CITY OF ALBUQUERQUE

January 13, 2017

**Re: Advance Auto Parts
10026 Central Ave. SE
Request for 30-Day Temporary C.O. - Accepted
Engineer's Stamp dated: 5-19-16 (L20D056A)
Certification dated: 12-22-16**

GRADING AND DRAINAGE PLAN

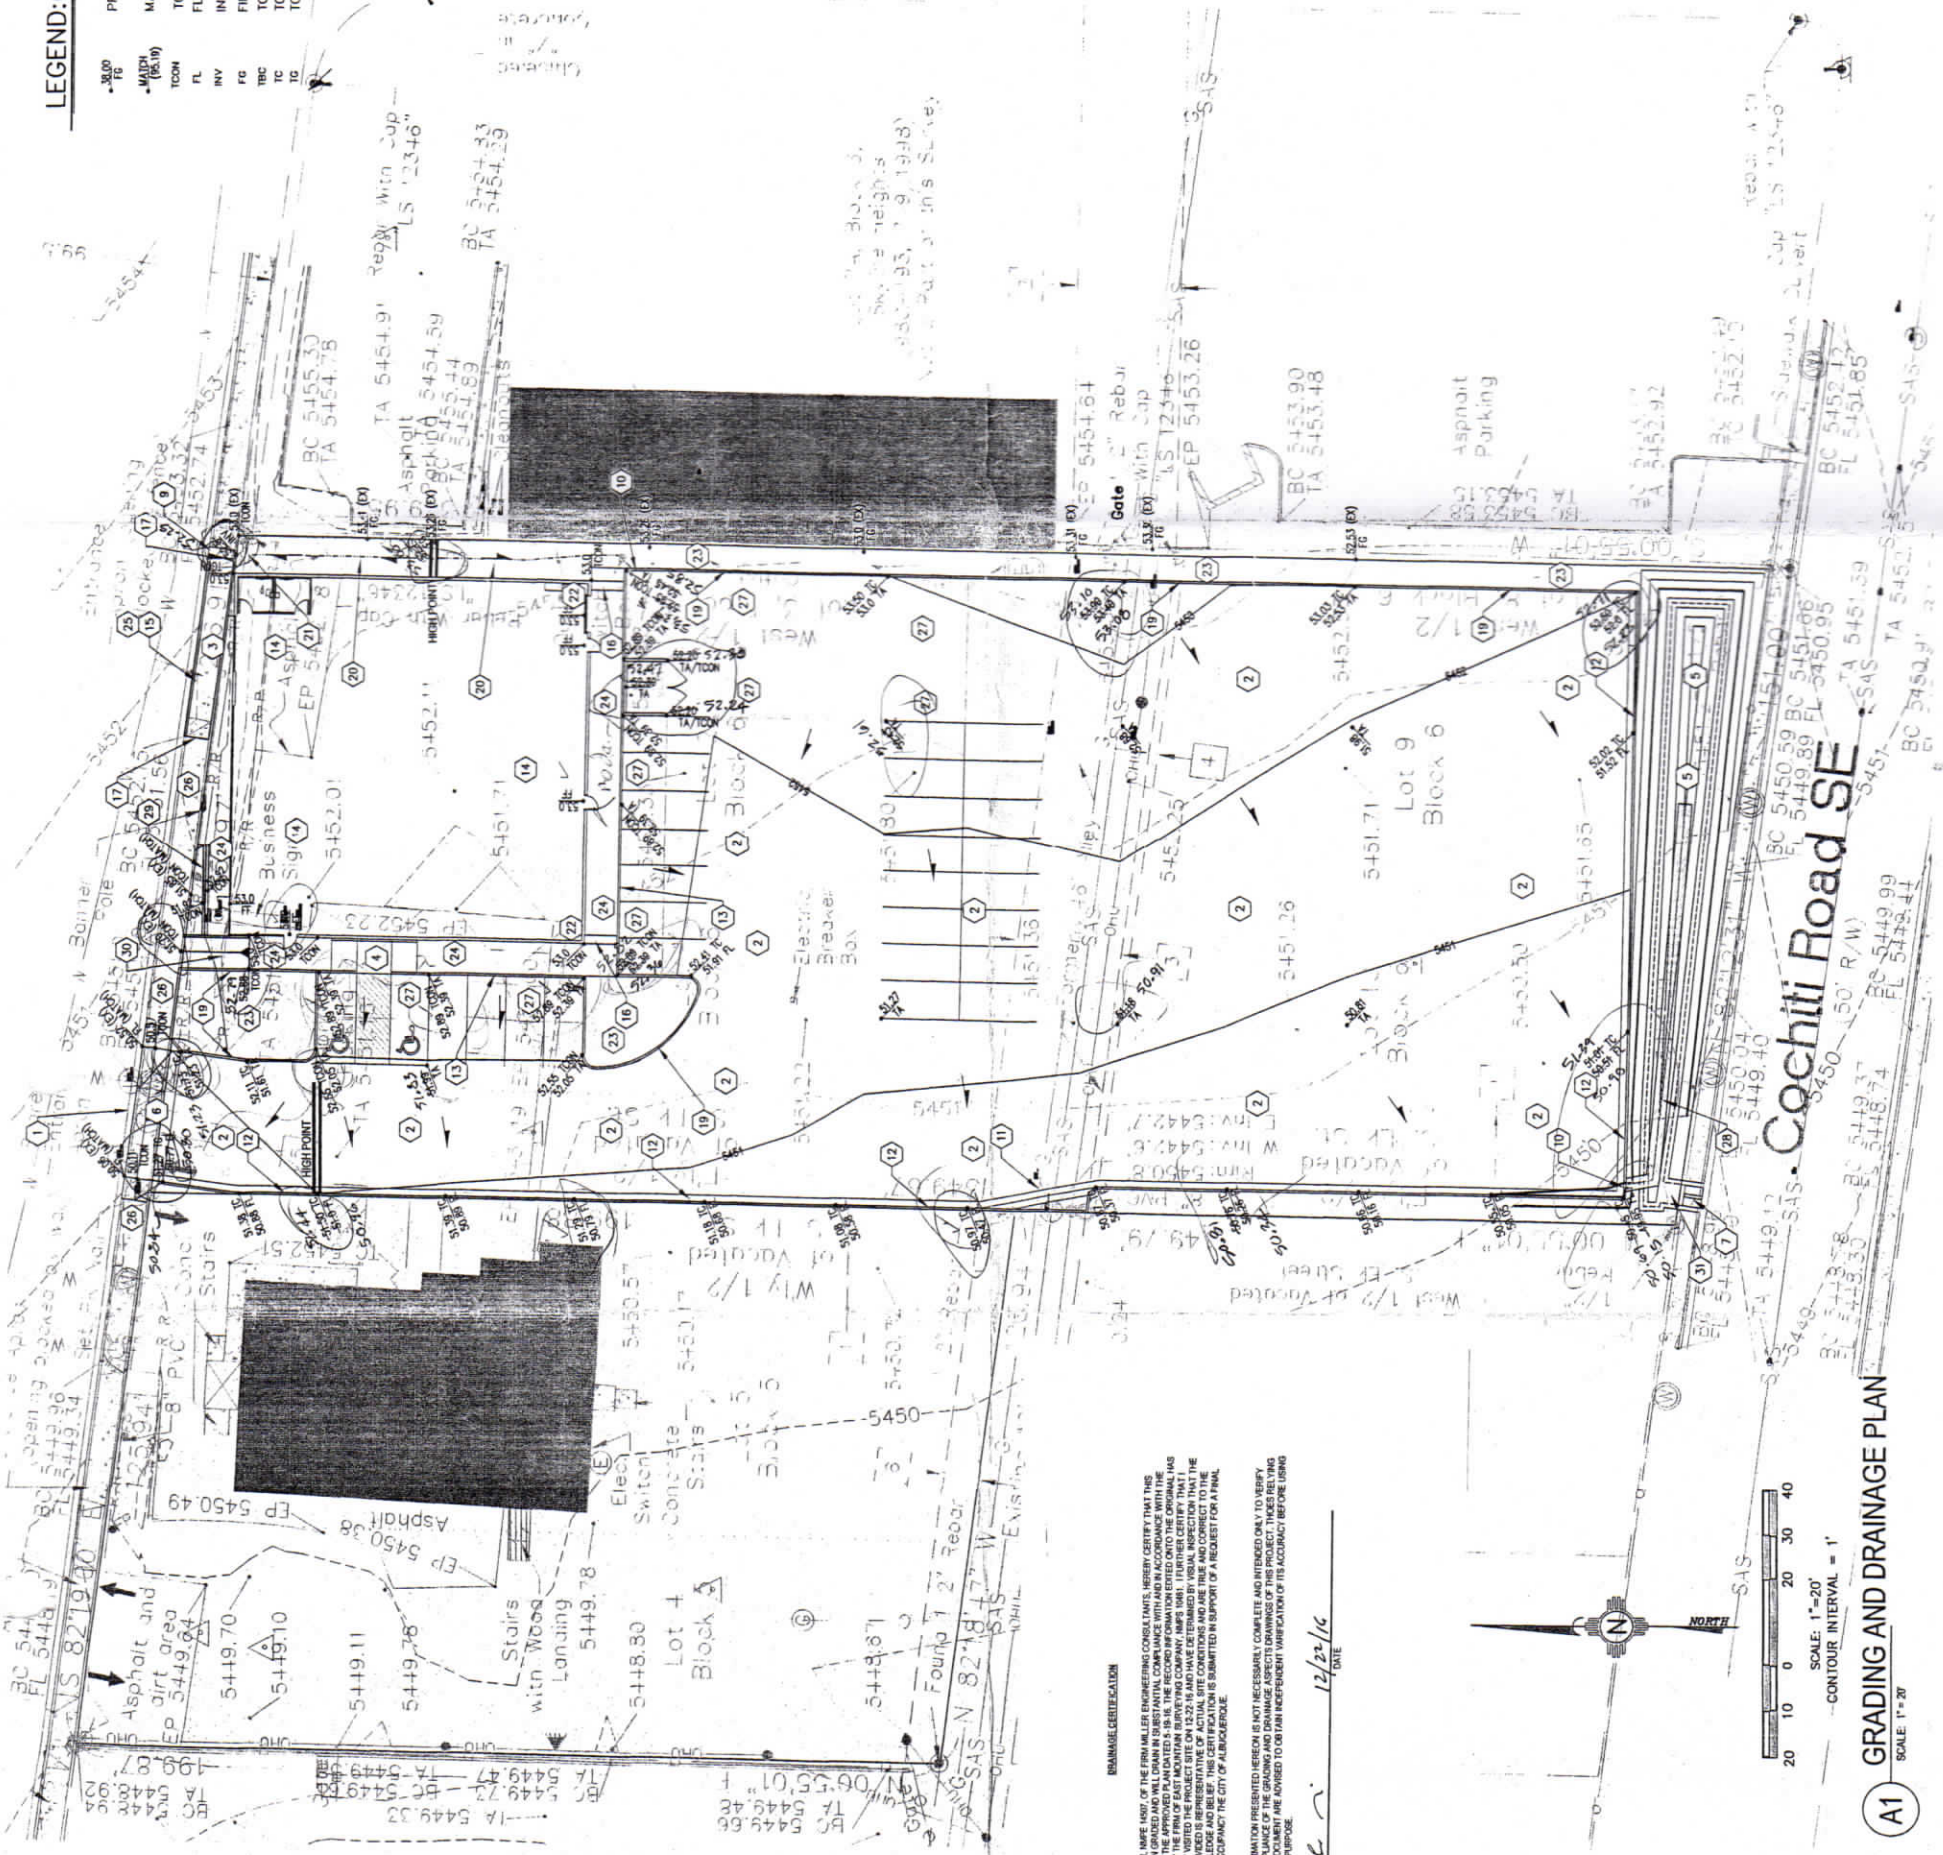
- The sidewalk culverts on the south side of the lot must be painted silver.
